June 1, 2011

Re: 102 Vermont Avenue – 405A F038 – build 10' x 12' screened house – permit #2011-05-1142

# 10'x12' Screen House

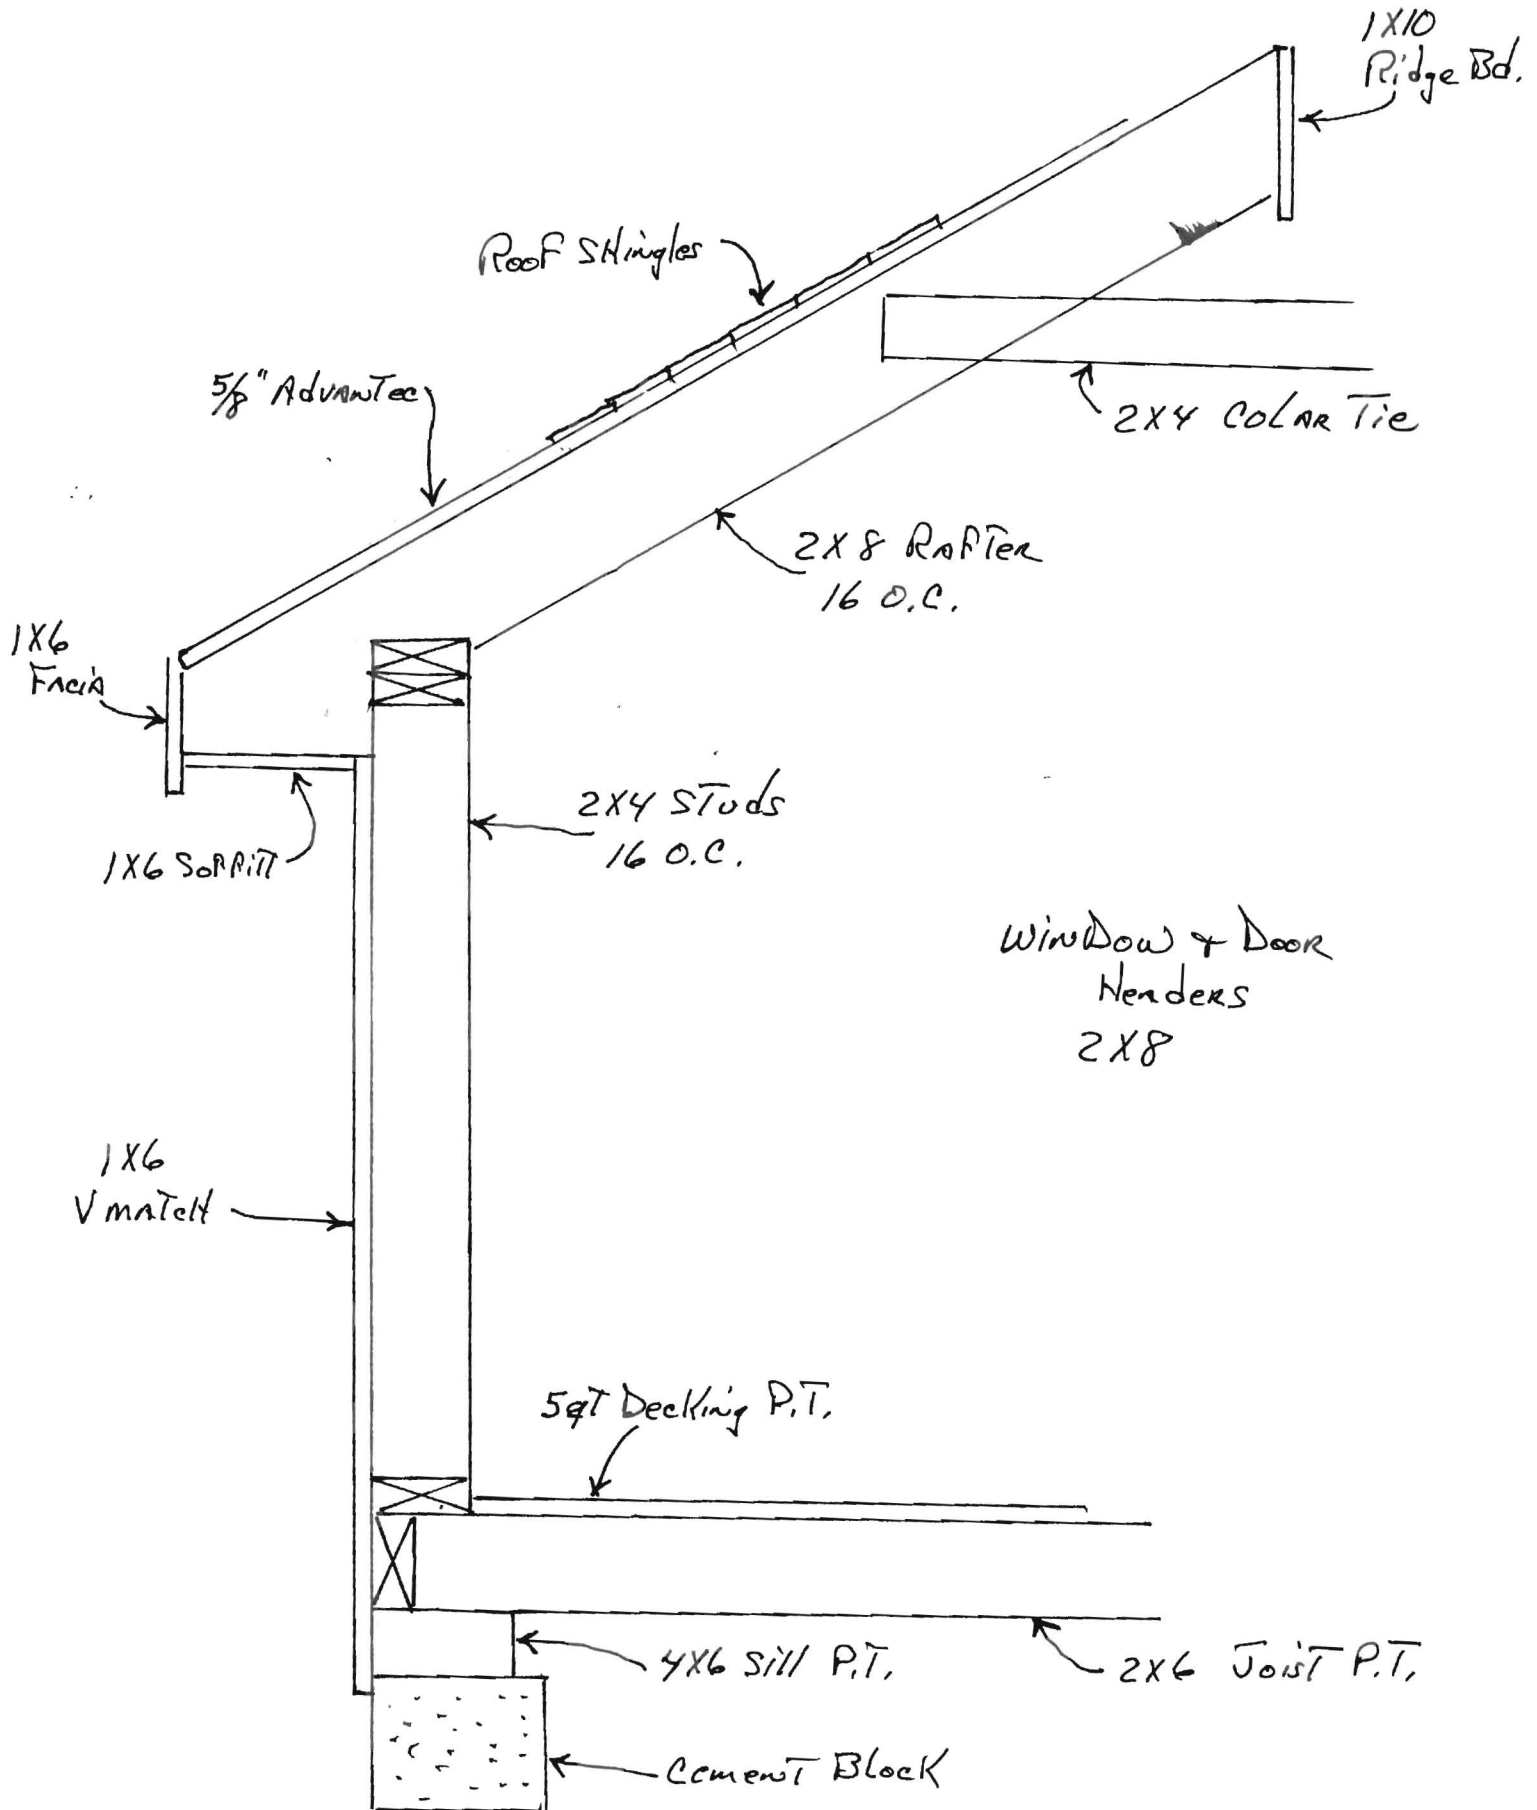
I have reviewed your application to build a ten foot by twelve foot screened house at your property at 102 Vermont Street. At this point your application cannot be approved because the proposed structure does not meet the required rear and side setbacks. I tried to call you to inform you of this, but your phone just rang and rang. I did leave a voicemail with your contractor, Michael Davis.

Your property is located in the R-3 residential zone. The required side setback and rear setback for an accessory, detached structure that is 144 square feet or less is five feet [section 14-90(d)(2)(b) & (d)(3)(b)]. The plot plan gives the rear setback as four feet and the side setback as four feet. You need to revise your plot plan to show that the rear and side setbacks are a minimum of five feet. The permit is on hold until the required setbacks are being met.
